Substantive response

To LPA	Welwyn Hatfield
LPA planning ref no	6/2022/1355/MAJ
Our ref	Pgo-1988
Site address	Former Beales Hotel Comet Way Hatfield AL10 9NG
Proposal description	Demolition of existing building and construction of 145 residential units (Use Class C3) with private and communal amenity space, landscaping, access, associated car and cycle parking, refuse and recycling storage and supporting infrastructure.
Date on fire statement	24/05/2022
Date consultation received	22/09/2022
Date response sent	21/10/2022

Headline Response from HSE ('Advice to LPA' - Some Concern)

Figure 4. Communal roof terrace arrangement indicating stair cores in green, evacuation lift in yellow, travel distances in blue arrows and storey exit width measurements in red.

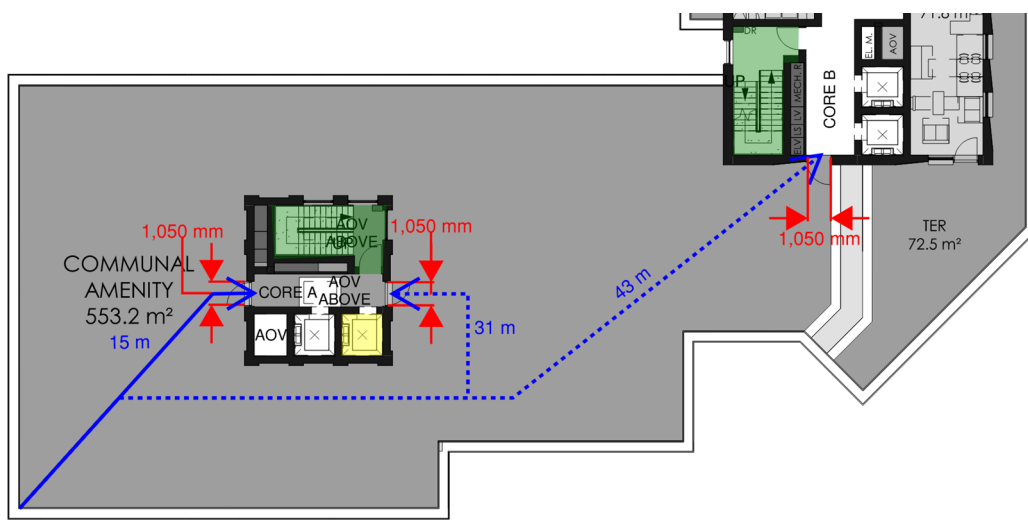
- 2.1 It is noted from section 7 of the fire statement that an occupancy of 512 persons has been calculated for the communal roof terrace. Should smoke enter stair core A, only one escape route would be available from this area i.e. via stair core B. This stair core would also be required for firefighting purposes. The occupancy figure of 512 persons is not suitable for this area. This will be subject to later regulatory consideration.
